**Addendum No. 2**

RE: Contract ID: C201568  
WBS# 34981.3.3  
F. A. # STP-1158 (4)  
Wilson County (U-3823A)  
SR-1158 (Airport Blvd.) From 0.2 Miles NE  
of NC-42 To 0.4 Miles SW of US-264A

Subject: **Application for the Modification of the Individual Section 404 and 401 permits, and Neuse River Riparian Buffer Authorization for TIP U-3823,** the proposed widening of Airport Boulevard (SR 1158) from NC 42 West to US 264 Alternate in Wilson, Wilson County; NCDOT Division 4. Federal Project No. STP-1158(2), State Project No. 8.2341801. Debit \$475 from WBS Element 34981.1.1.

N.C. DEPT. OF TRANSPORTATION
 DIVISION OF HIGHWAYS
 WILSON COUNTY
 U-3823
 SR 1158 (AIRPORT BLVD.) FROM
 EAST OF NC 42 TO EAST
 OF US 264-A
 DATE: APRIL 2007
 SHEET 6 OF 15

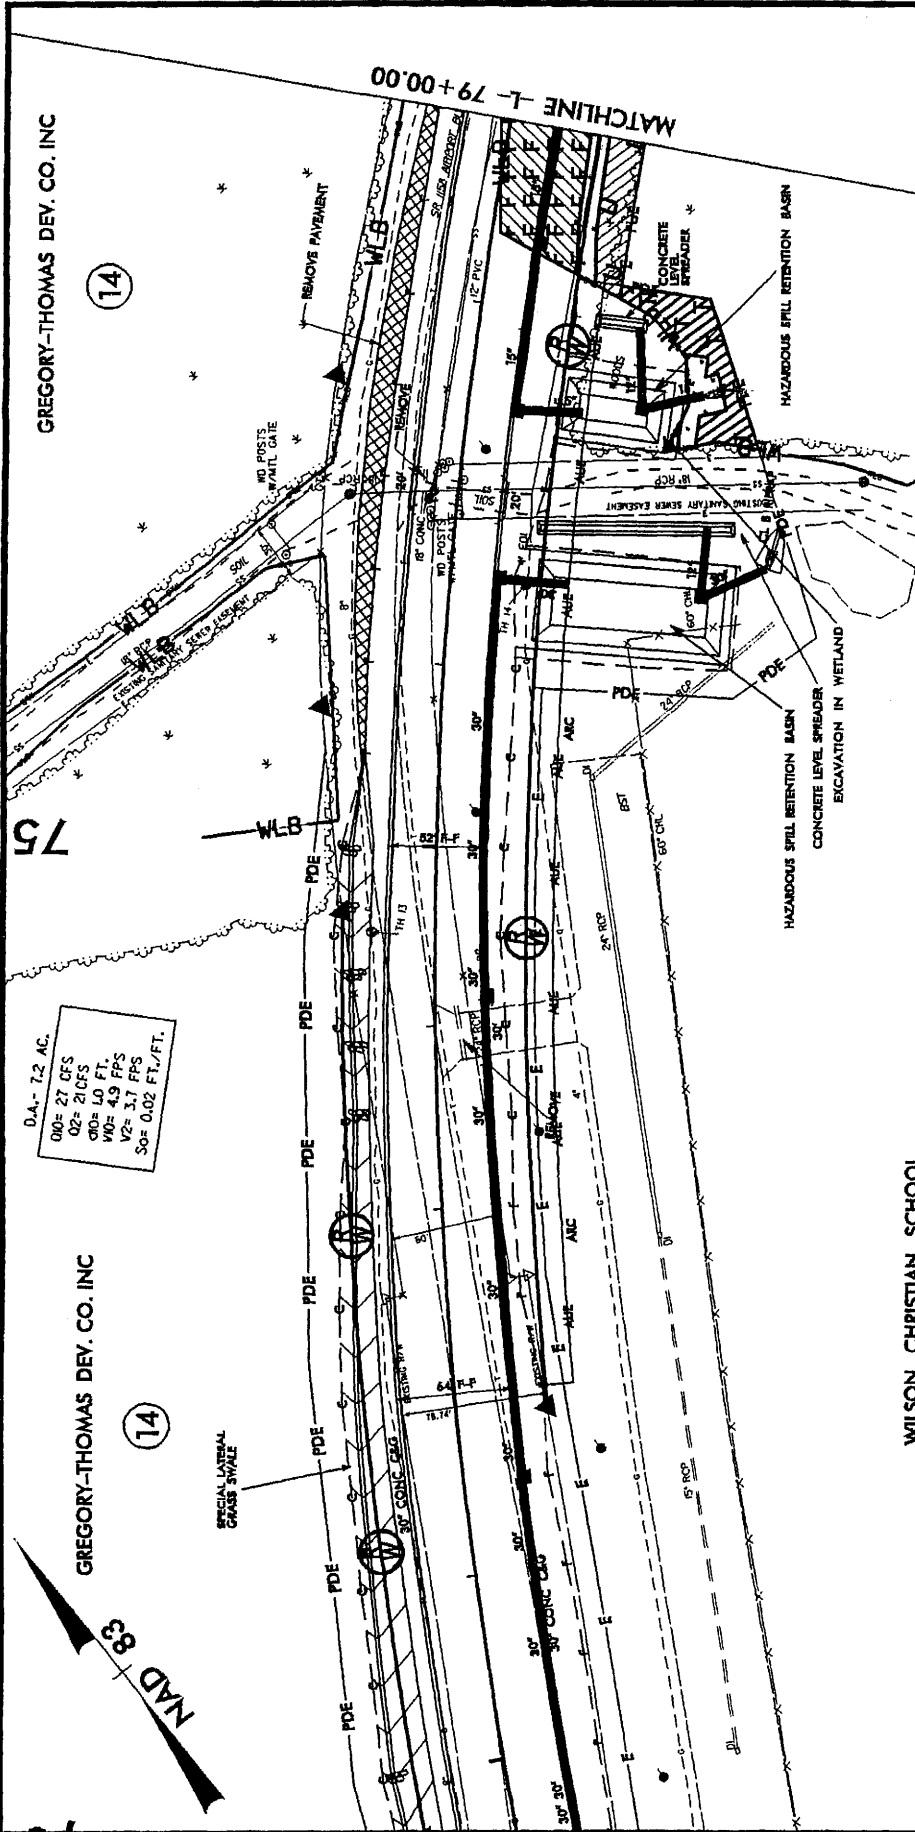
Since the previous permit, in which both sections were permitted, there has been a design change for the project. The previous permit granted impacts to Waters of the US to four sites. Sites 3 and 4 are located in the "B" section, which has been constructed. Sites 1 and 2 remain in the "A" section and contain changes from the previous permitted impacts as described below:

Site 1 (44+95-45+55-L-)

There are NO changes to the amount of impacts for this site, however, the permit drawings have been clarified from "temporary impact in wetlands" to "temporary fill in wetlands".

N.C. DEPT. OF TRANSPORTATION
 DIVISION OF HIGHWAYS
 WILSON COUNTY
 U-3823
 SR 1158 (AIRPORT BLVD.) FROM
 EAST OF NC 42 TO EAST
 OF US 264-A
 DATE: MAY 2007
 SHEET 7 OF 15

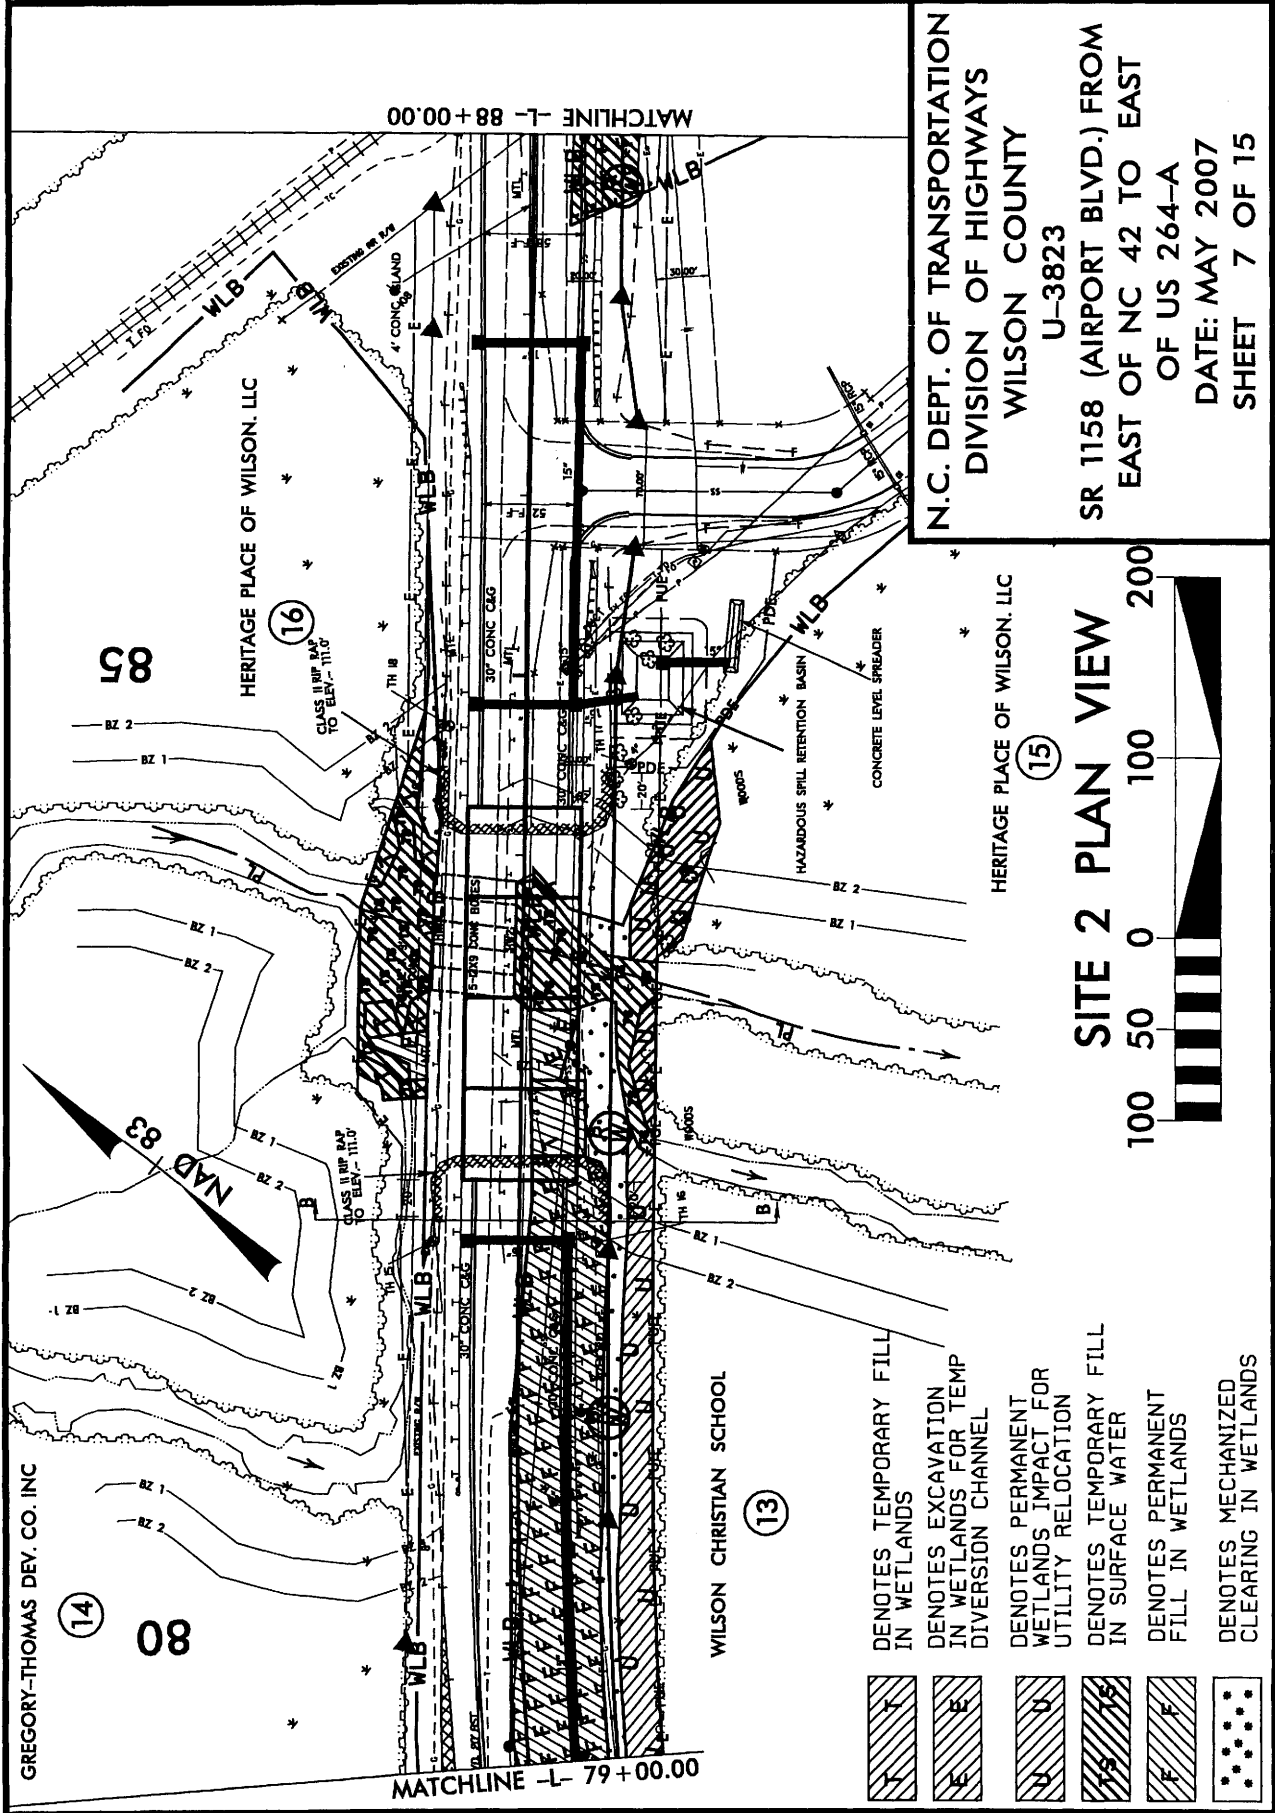
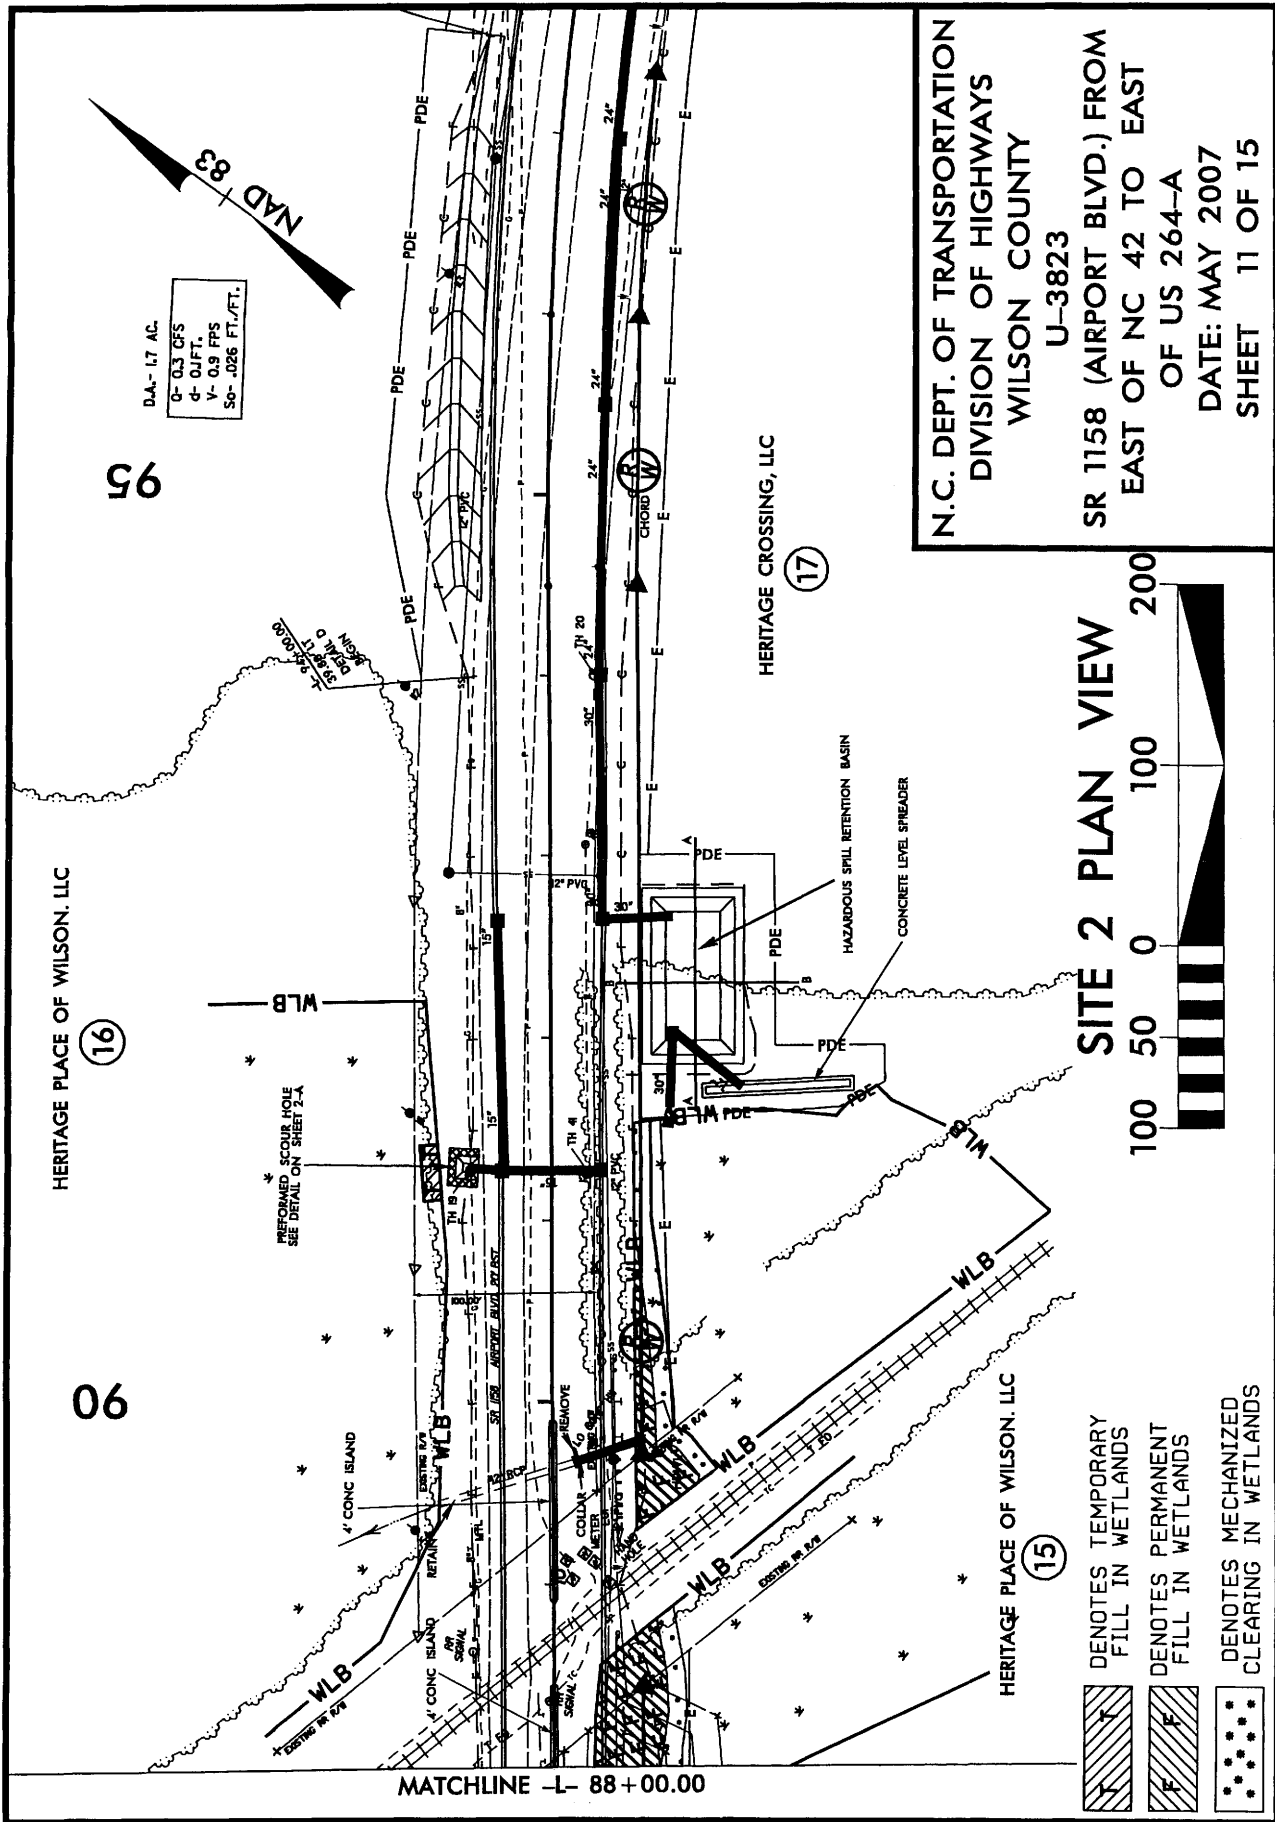
Due to a re-evaluation of the construction and phasing methods for the removal of the box culvert and replacement with a bridge, along with the relocation of utility and railroad signal control boxes, an increase to wetland impacts has occurred at this site.

NCDOT continues to propose to remove the 12'x 9' pentuple barrel culvert, and replace it with a 4-span, 205-foot cored slab bridge carrying Bloomery Swamp. However, to allow for a cleaner and expedited removal of the existing box culvert, NCDOT will remove the entire culvert at one time. To accommodate this removal, the total permanent impacts to wetlands have increased as shown in Table 1 below, and in the attached drawings.

Permanent Fill in Wetlands (ac)	Excavation in Wetlands (ac)	Mechanized Clearing in Wetlands (ac)	Temp Fill in Wetlands (ac)	Temp Fill in Surface Water (workpad) (ac)
Previously Permitted Impacts	0.547	0.001	0.299	0.118	0.066
Requested Modification	0.585	0.032	0.268	0.132	0.175
Difference	+0.038	+0.031	-0.031	+0.014	+0.109
